Project EN070005: Southampton to London Pipeline Project
Interested Party: Nick Jarman, reference: 20022545

Attached is the Deadline 5 submission on behalf of the Neighbours and Users of Queen Elizabeth Park. This contains comments on responses to the ExA's Further Written Questions and comments on responses submitted for Deadline 4.

Deadline 5 Submission on Behalf of the Neighbours and Users of Queen Elizabeth Park

**Drawing title**  
 QUEEN ELIZABETH PARK  
 ARBORICULTURAL SURVEY

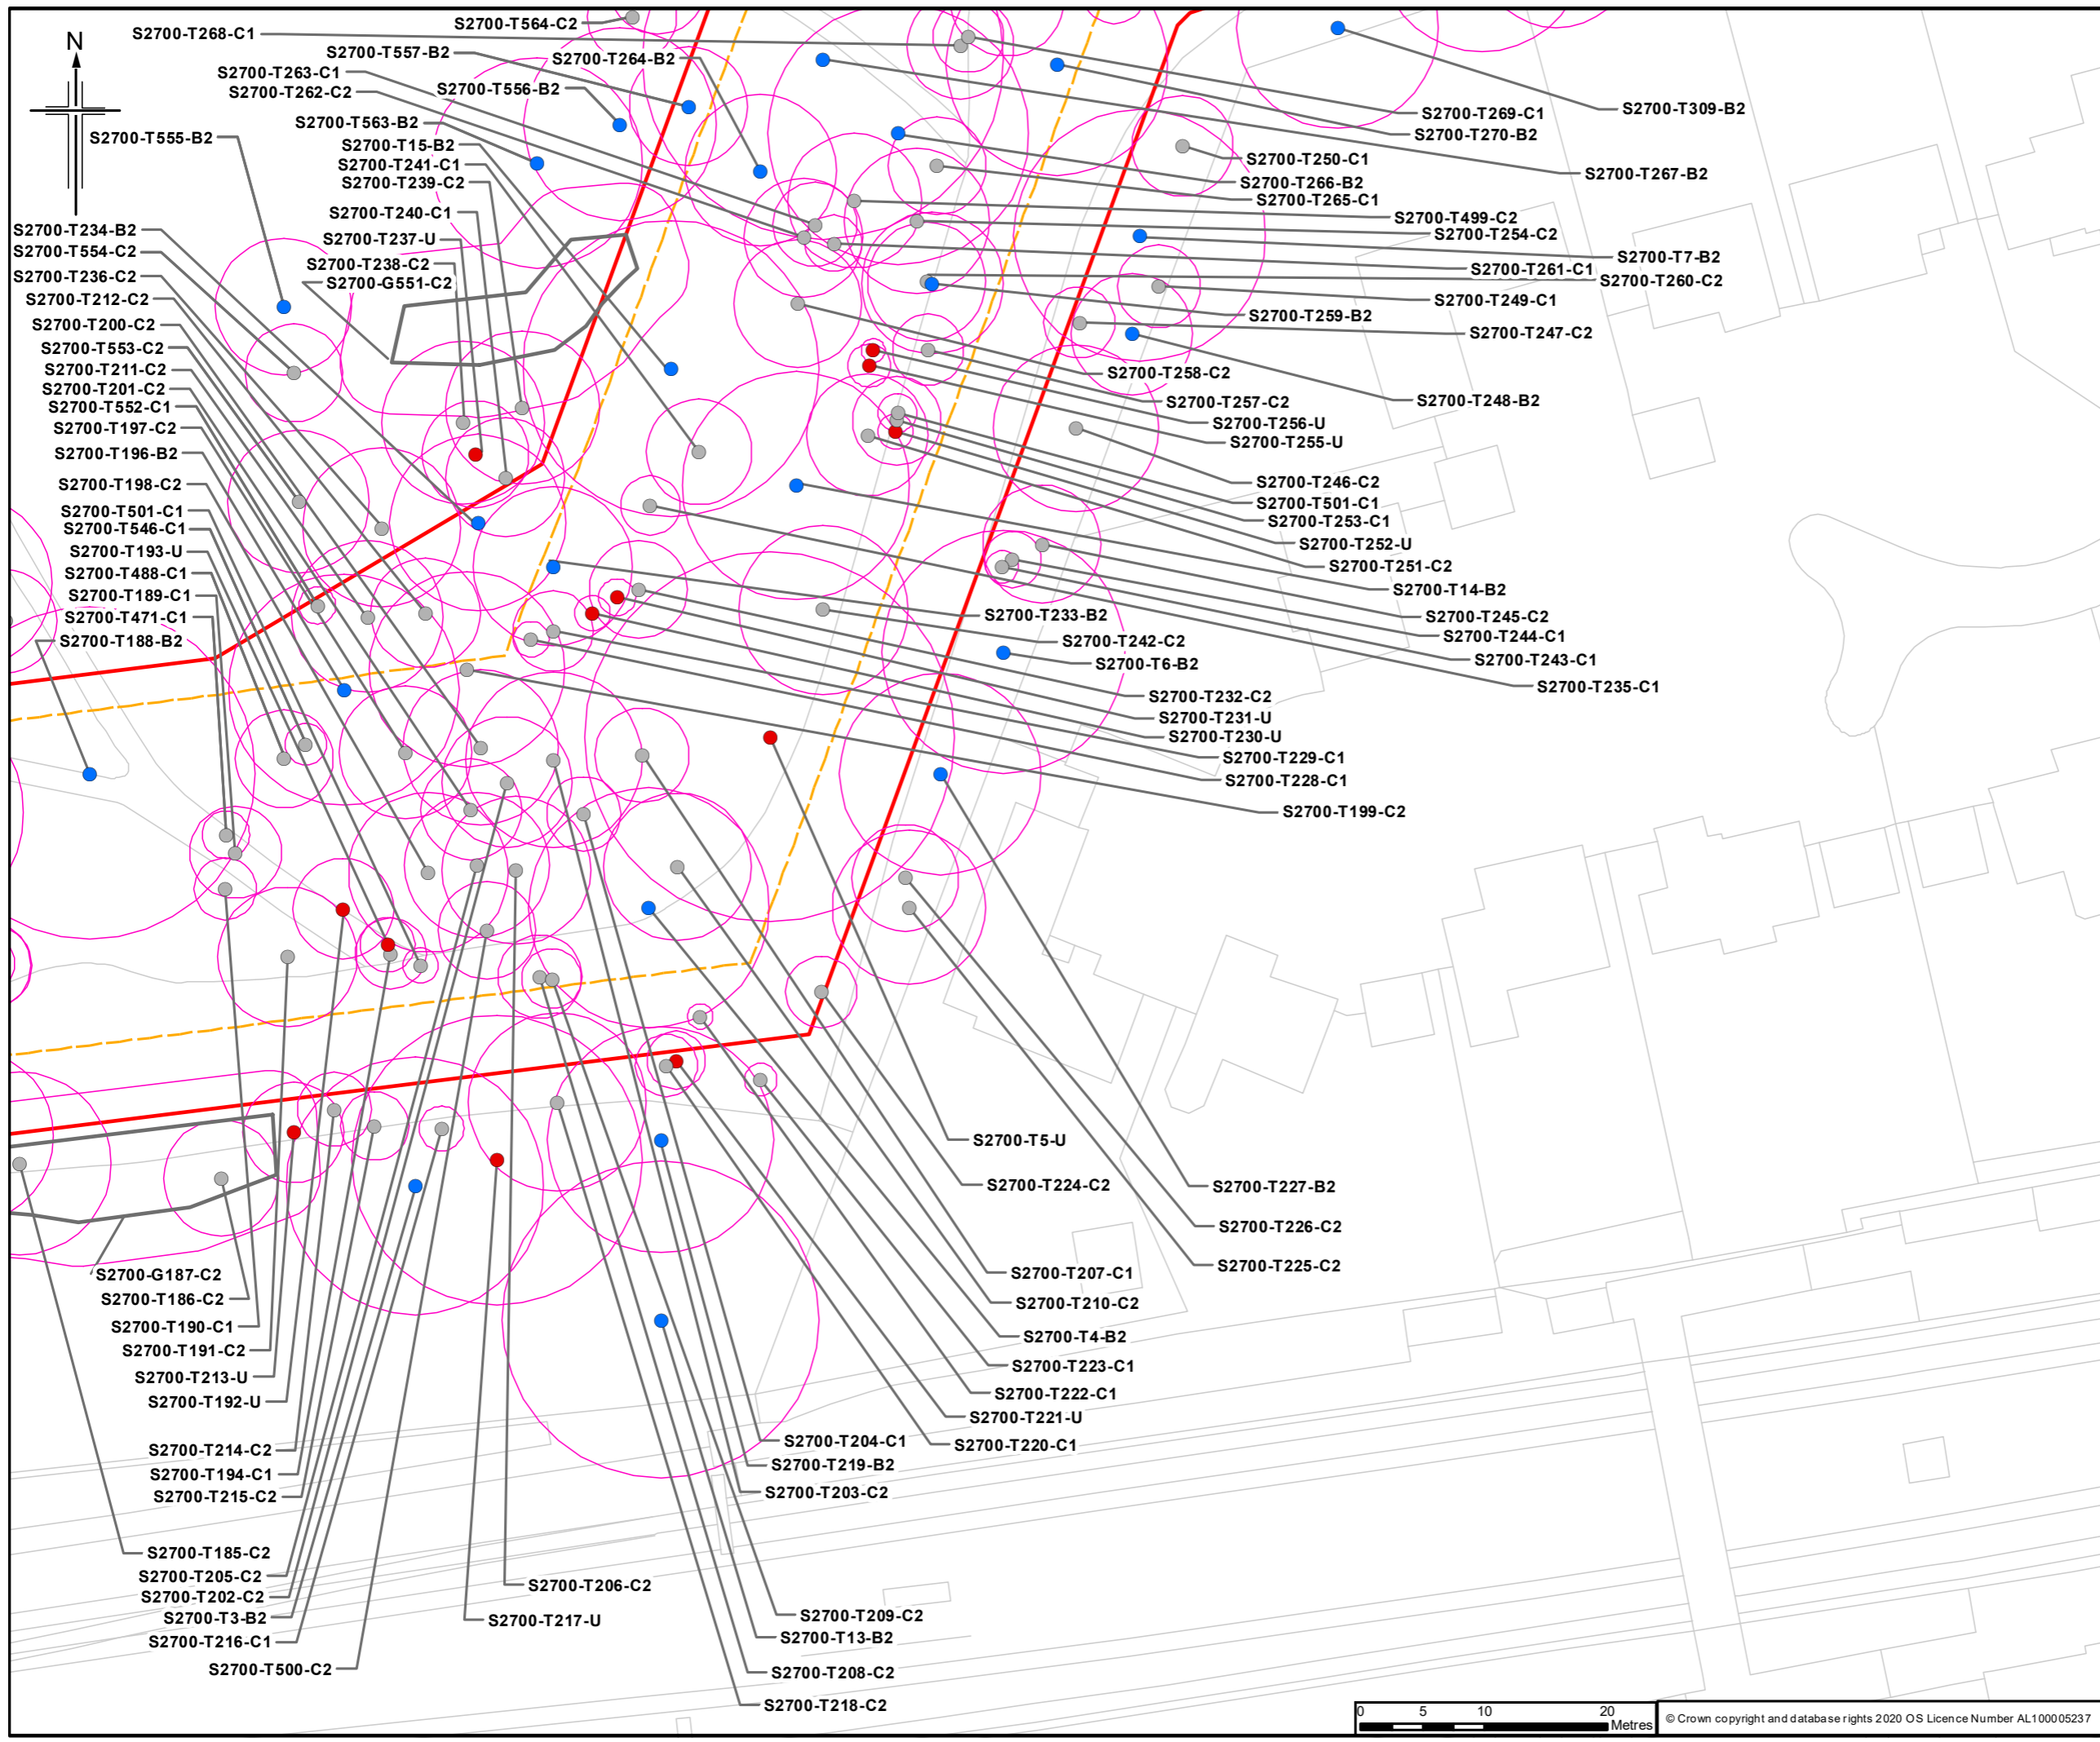
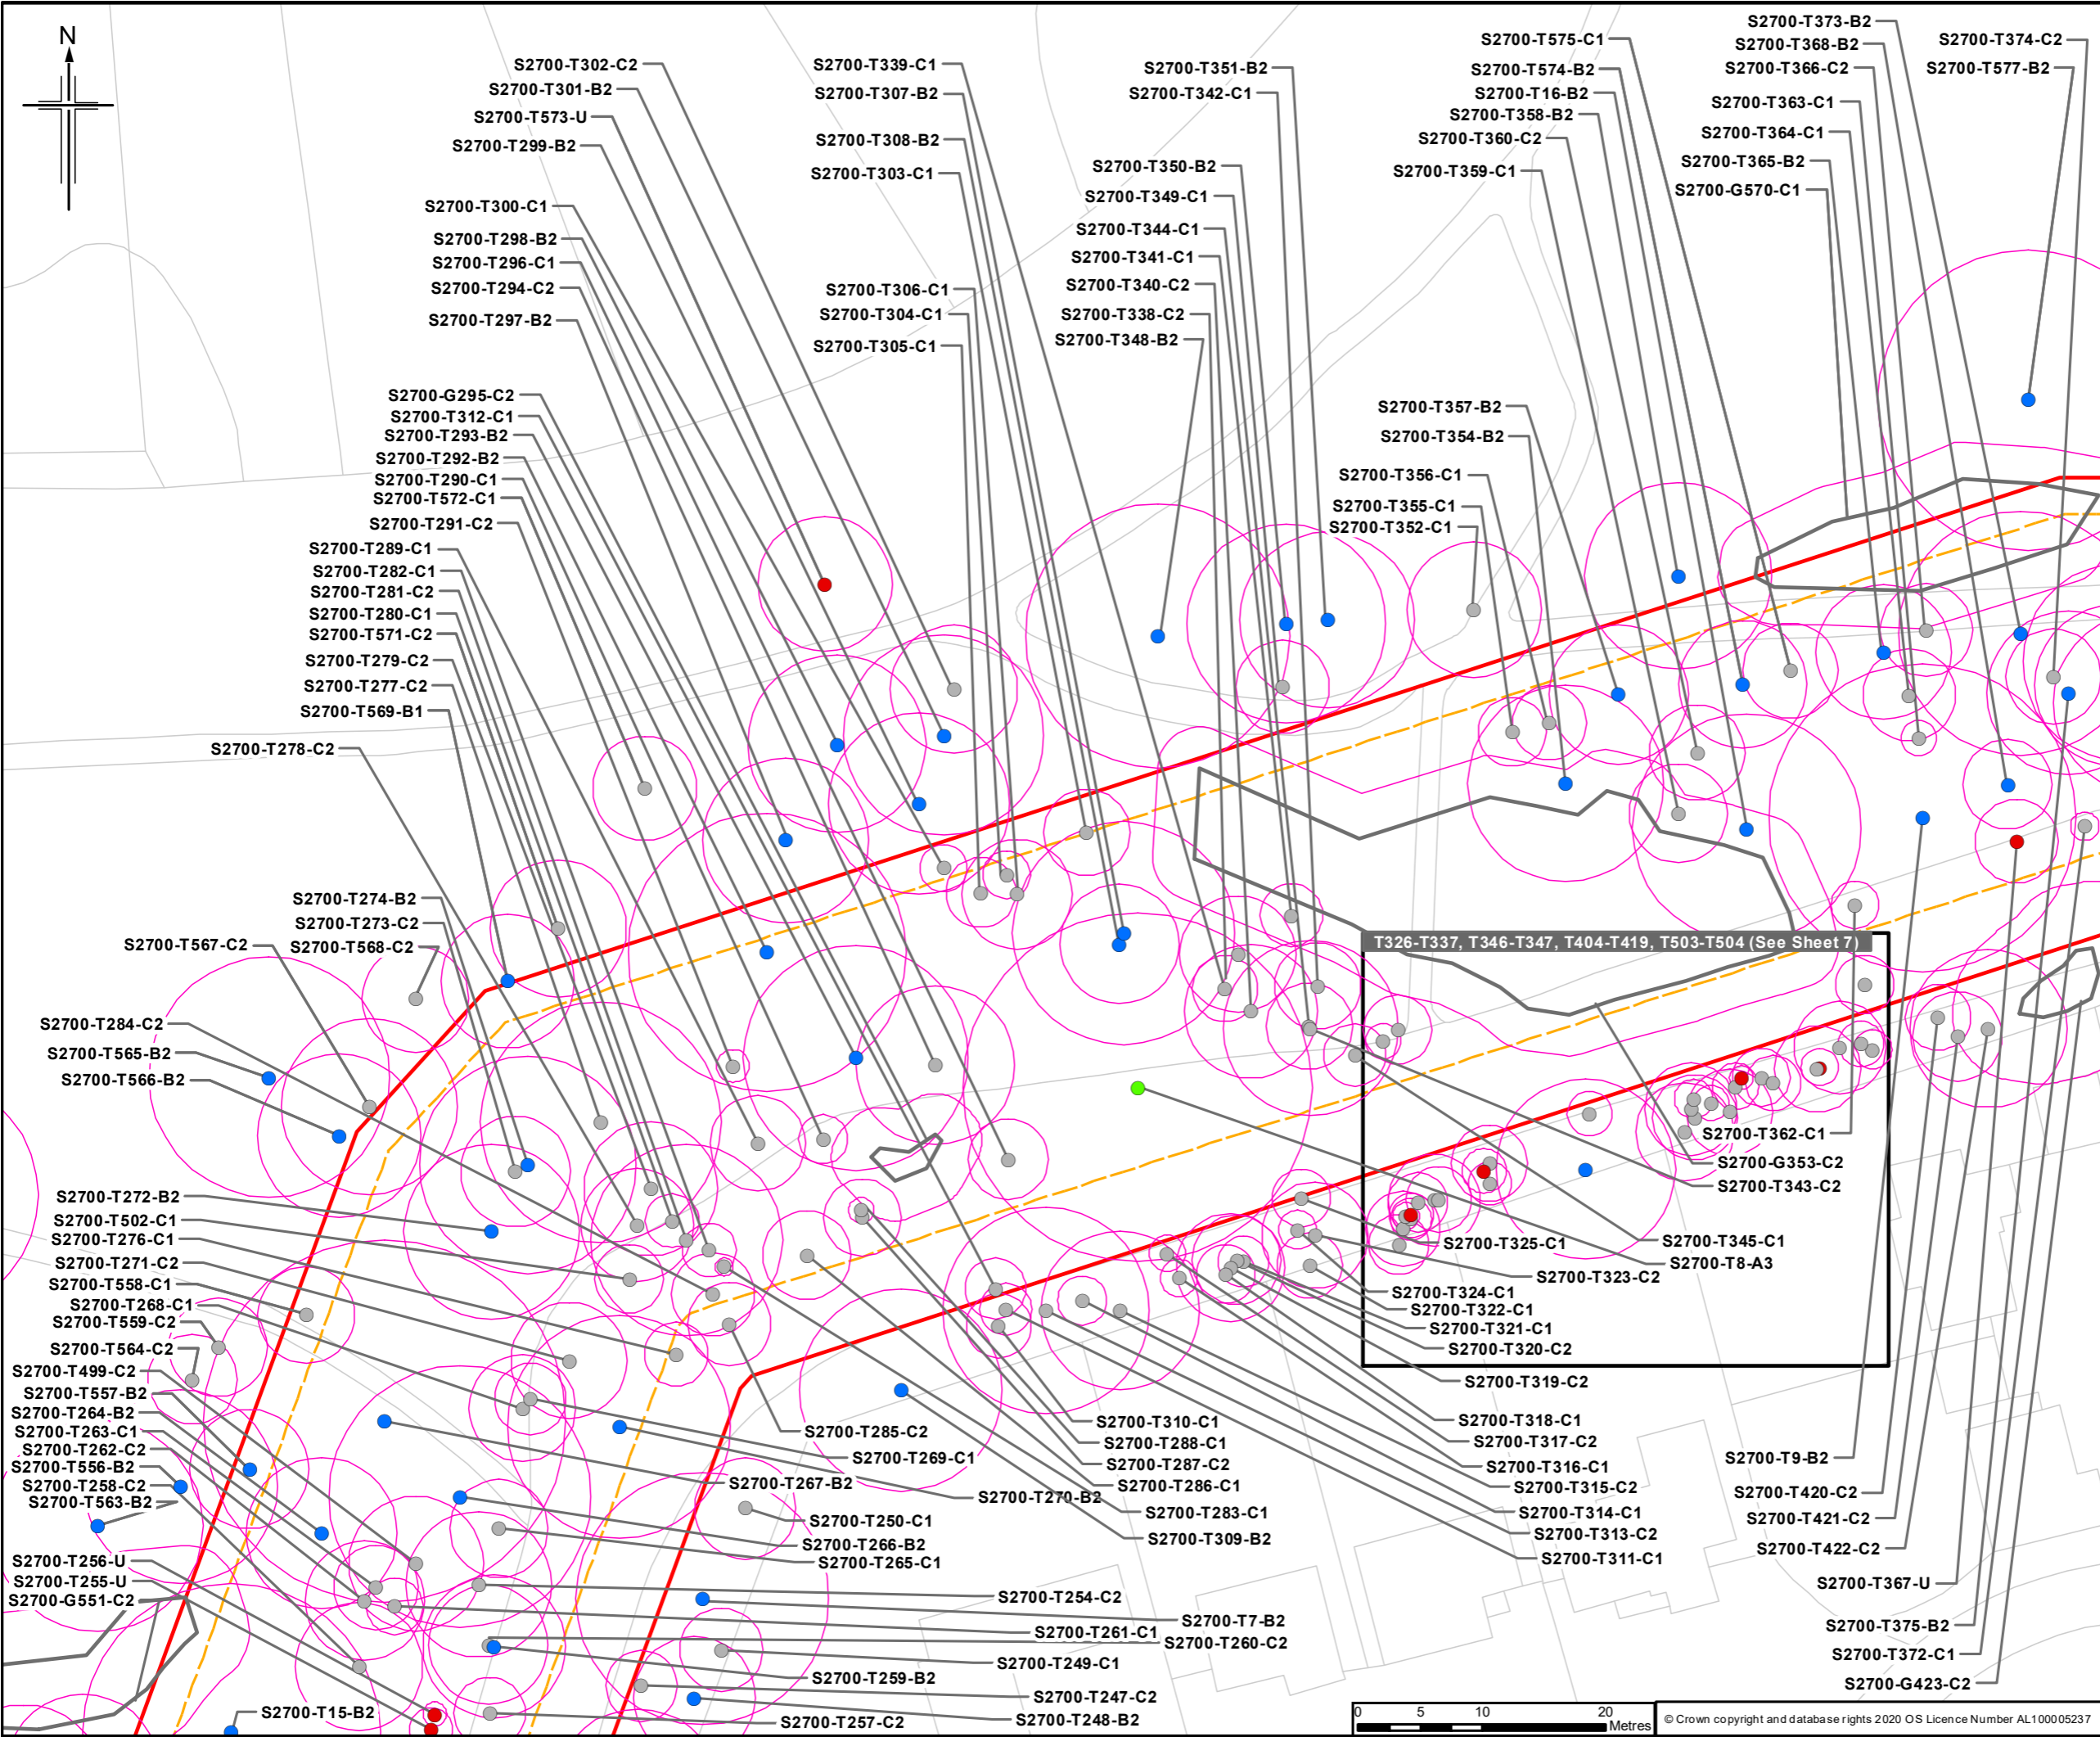
The tree survey lists over 580 trees (including groups), almost all of which are within the Order Limits. Although the survey is very comprehensive and mostly accurate, Esso omitted to identify which trees were classified as Notable or Veteran in the Woodland Trust's Ancient Tree Inventory (ATI). In the absence of this information, we have completed the work to map the Notable and Veteran Trees on the survey.

We have produced annotated versions of sheets 1-5 of the Queen Elizabeth Park Arboricultural Survey drawings, showing all trees listed in the ATI. These can be found in Appendix B. Extracts from these drawings are also used to illustrate specific points in the sections which follow.

Whilst we have not checked every single tree in the survey, we noticed a number of minor inaccuracies whilst we were correlating the survey with the ATI:

1. Path position near T432 and T433 - these trees are on the other side of the path.
2. T249 is listed as a sweet chestnut but is actually an oak.
3. A Notable Tree within the proposed Cabrol Road construction compound has been omitted.

We estimate that the total length of trench in the park is 532 metres, of which 472 is in narrow working area NW17. This is the length required to connect the TC018 pit to the proposed auger boring pit for TC019. 197 metres of the proposed trench is in root protection areas of Notable and Veteran Trees. That is 37% of the entire trench length within the park.

The root protection areas of 12 Notable Trees and 2 Veteran Trees will be violated by trench digging for the pipeline route as proposed. This will cause damage to the root systems and in many cases it is highly likely to kill the tree. BS5837:2012 states that:
